# Derrygreenagh Power Submission

**Cllr Liam Quinn**

319023 (SID Application)

Combined Cycle Gas Turbine and Open Cycle Gas Turbine Thermal Power Plant, Electricity Grid Connection including 2 no. substations, and associated buildings, plant, site works, service and ancillary development.

NOTES:

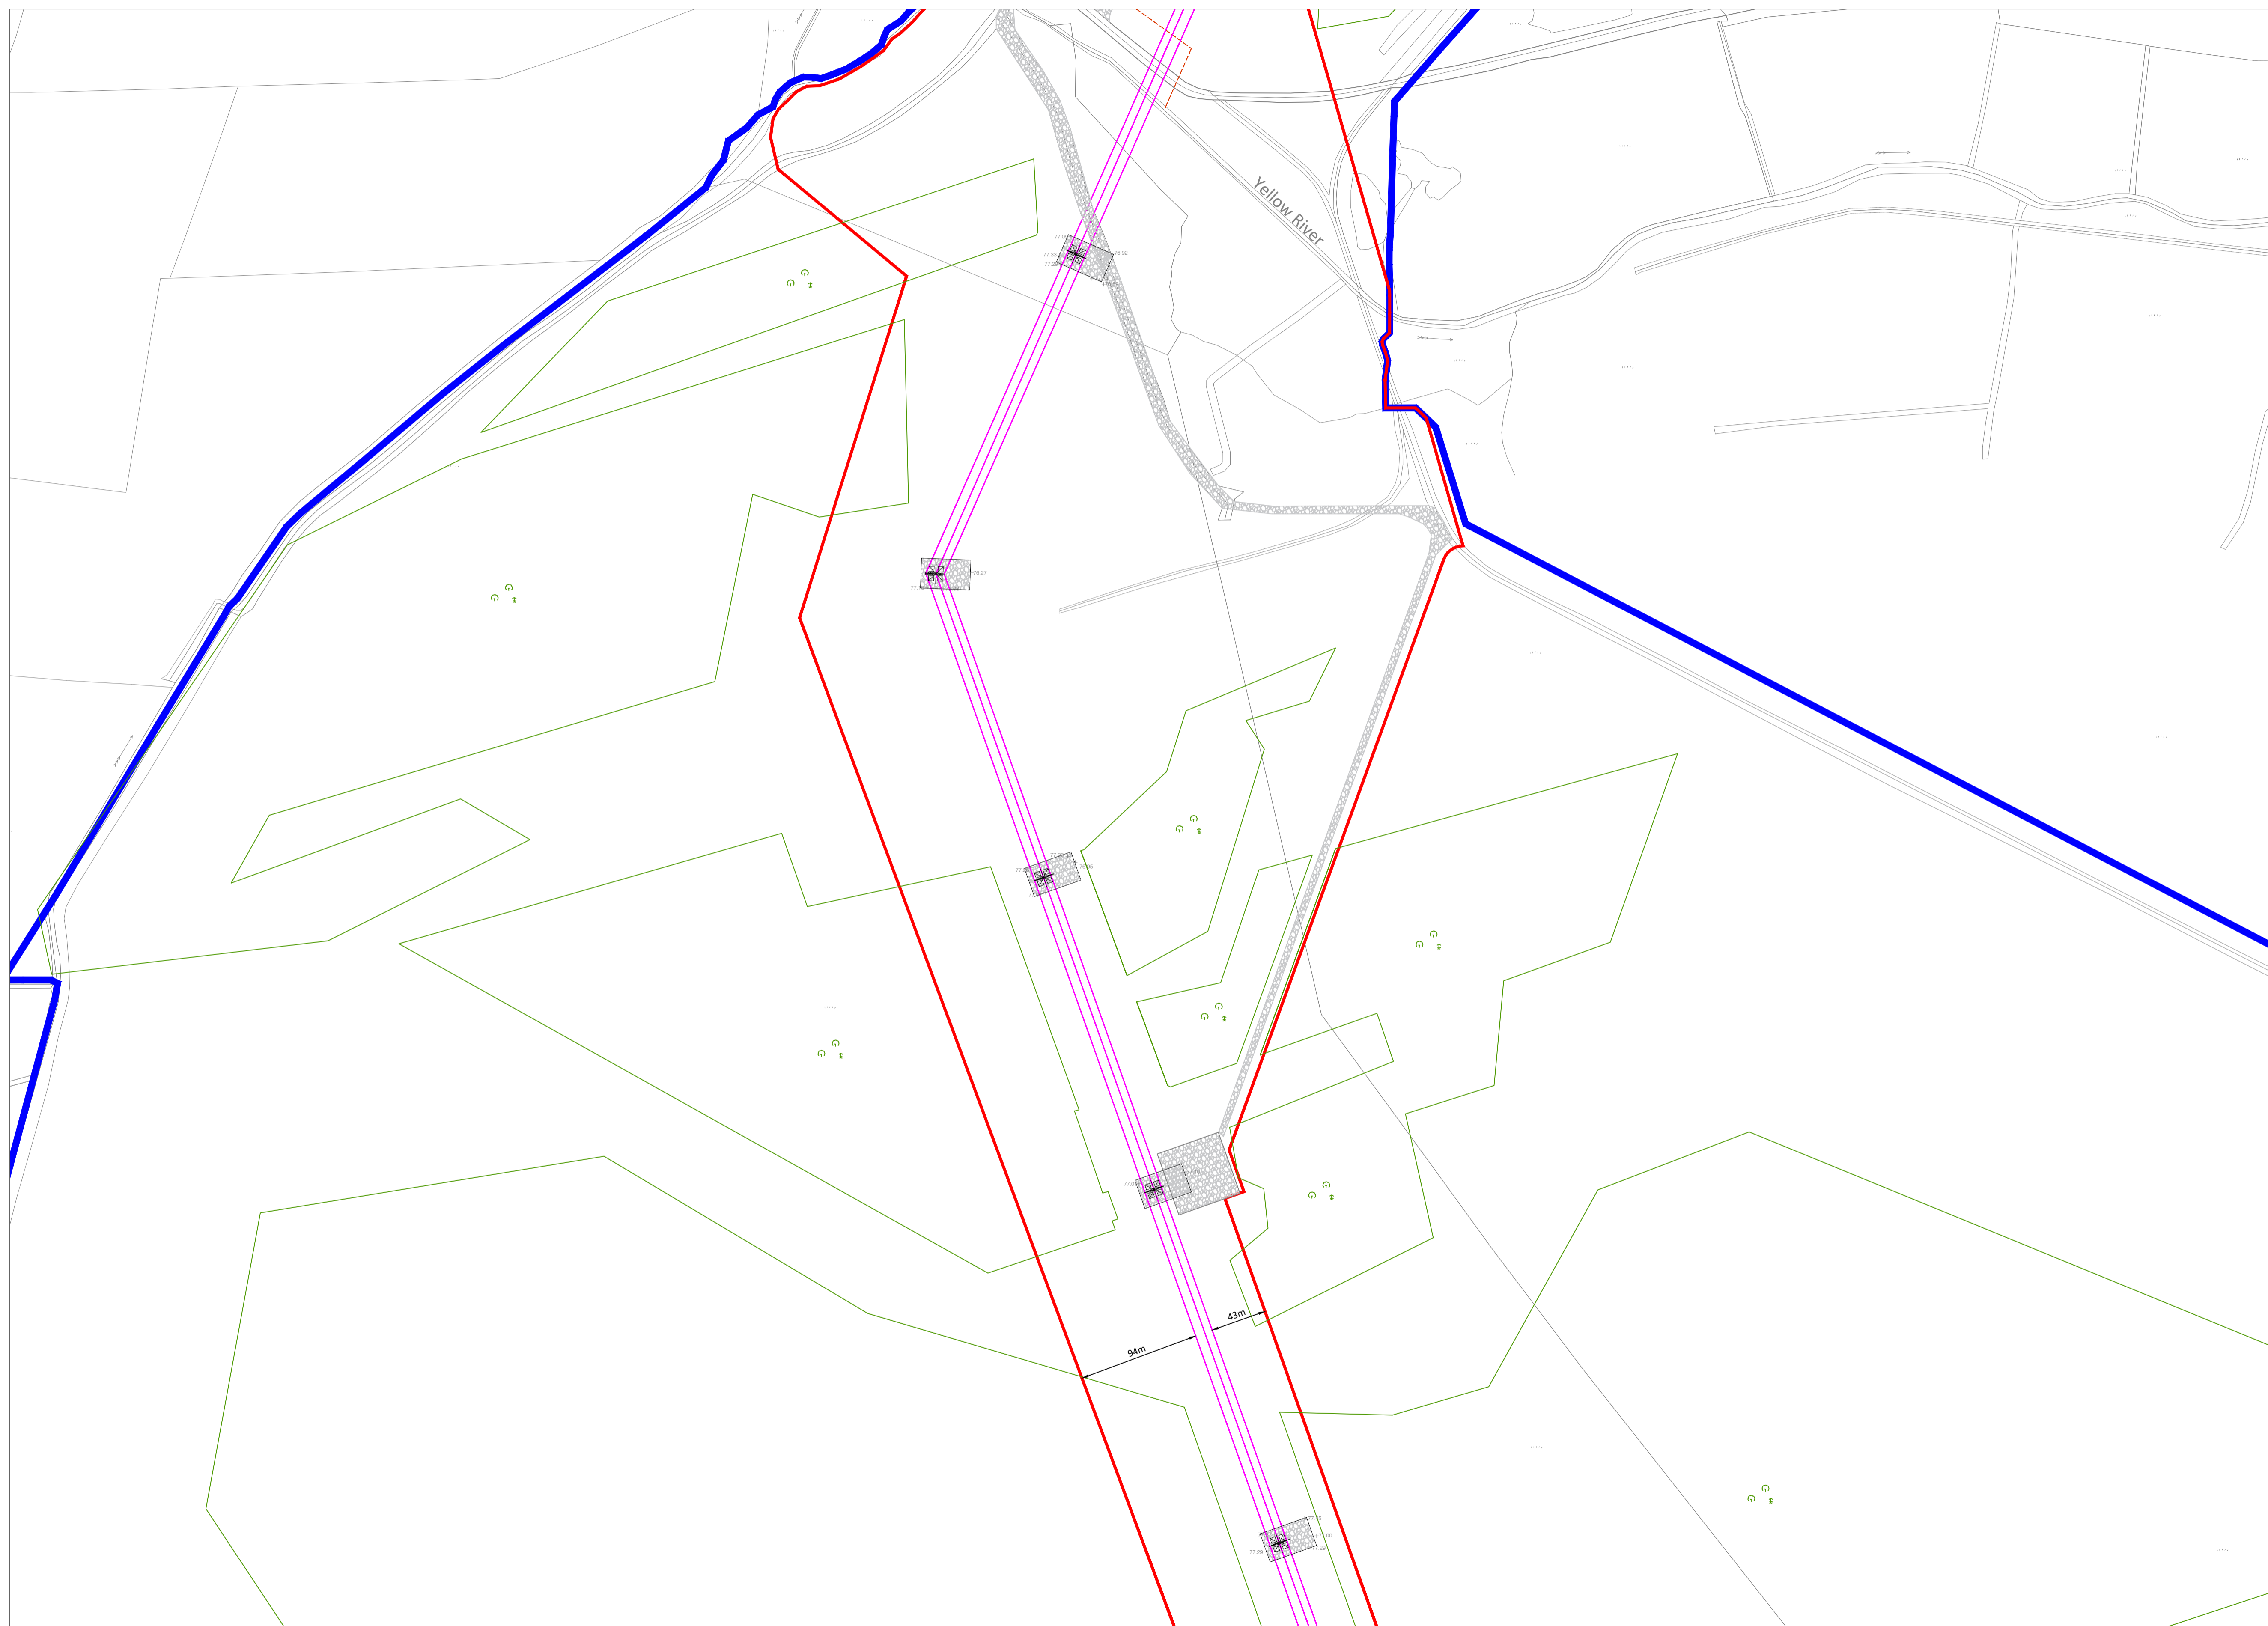
1. The cabling connecting this development to the substation be located entirely underground with no **overhead wires/pylons permitted**.

The proposed cable way will have a major visual impact on the surrounding countryside. This imposition can be overcome by undergrounding the entire cable way from Derrygreenagh to Tubberdaly.
